APPLICATION BY LIVERPOOL BAY CCS LIMITED FOR AN ORDER GRANTING DEVELOPMENT CONSENT FOR THE HYNET CARBON DIOXIDE PIPELINE

**APPLICATION REF EN070007
PIBLINELL CARBON DEUOCCSID HYNET / HYNET CARBON DIOXIDE PIPELINE**

**FLINTSHIRE COUNTY COUNCIL'S RESPONSE TO TABLE 2-17 OF [REP5-015] – DEADLINE 5 SUBMISSION - D.7.37 APPLICANT'S COMMENTS ON
SUBMISSIONS RECEIVED AT DEADLINE 4**

SUBMITTED AT DEADLINE 6 – TUESDAY 18 JULY 2023

WATERCOURSE CROSSINGS

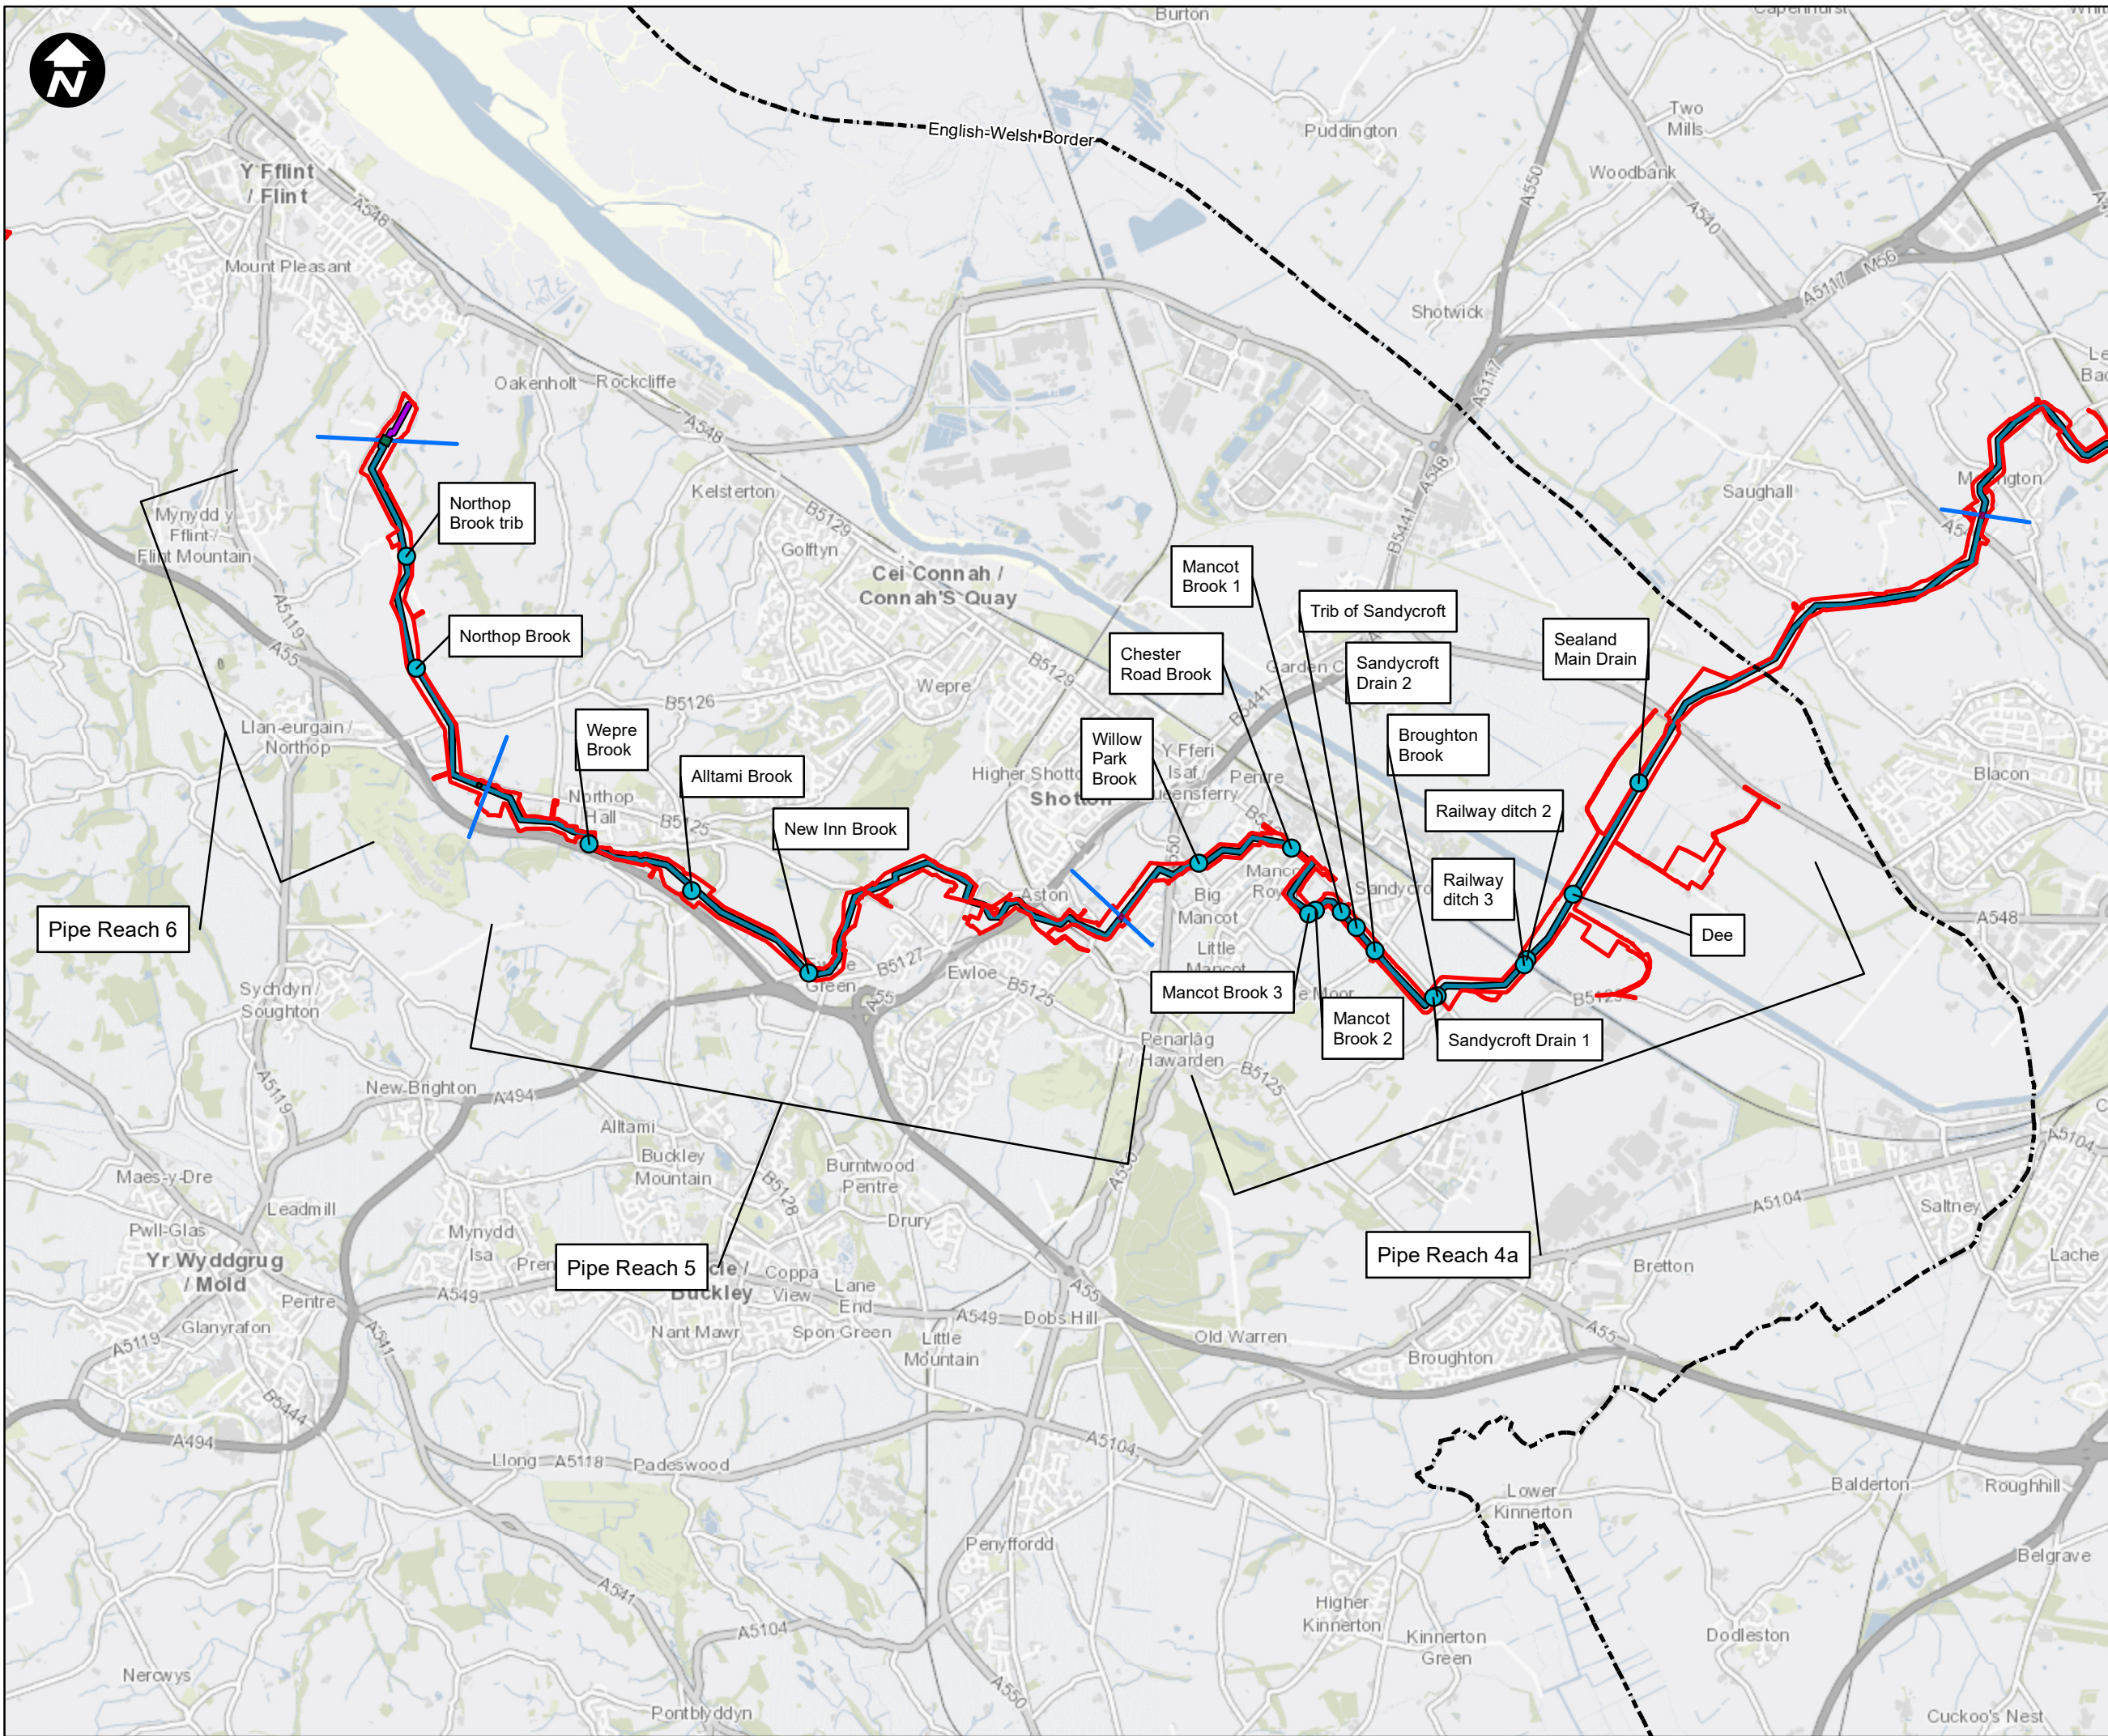
2.16.4	1.4	Document D.6.3.18.5 FCA Part 1 Rev A Table 1 Watercourse Crossings [APP-168] on Page 17 states there are 12 Ordinary Watercourse crossing/intersection points within Flintshire. It may be suggested that following further site investigation and excavation works as the scheme progresses, further culverted ordinary watercourses may be discovered. There are several significant ordinary watercourse crossings within the proposals that possess known areas of surface water flood risk associated. It is considered that there is insufficient information within FRA, surface water drainage strategy or the D.6.5.4 Outline Construction Environmental Management Plan (OCEMP) [APP-228] evidenced at this time to fully understand and assess the impacts that the pipeline and associated works would have on the watercourse both for temporary and permanent works.	<p>The Applicant has submitted an Outline Surface Water Management and Monitoring Plan (OSWMMP) (document reference: D.7.43), which provides recommendations and guidance to the Construction Contractor on the requirements and measures to manage surface water quality, volumetric control, discharge locations and flood risk from temporary works such as construction compounds.</p> <p>In addition, the OSWMMP also provides preliminary guidance for working near watercourses and the management of flood risk during the construction phases from known areas of flooding from surface water flooding, fluvial and tidal flooding.</p> <p>The Flood Consequences Assessment [REP4-180] assesses</p>	<p>FCC notes the information submitted in relation to this matter as detailed in the column to the left. However, FCC will still require the information requested at DL4 in Document Ref [REP4-288] under points 2.16.5- 2.16.17 below to fully assess the impact and risks of the works on the intersections of ordinary watercourse.</p> <p>At present FCC do not have sufficient information to fully understand and assess the impacts that the pipeline and associated works would have on the watercourse both for temporary and permanent works.</p>

<p>the risk of flooding to the permanent works only, and the OSWMMP outlines the mitigation measures to be adopted by the Construction Contractor for the temporary works to prevent impacts on flood risk and watercourses.</p> <p>The Construction Contractor will also provide their Risk Assessment and Method Statements for the detection and prevention of impacts on buried utilities (charted and uncharted) before the construction phases to ensure that there is no impact (on assets such as culverts).</p>
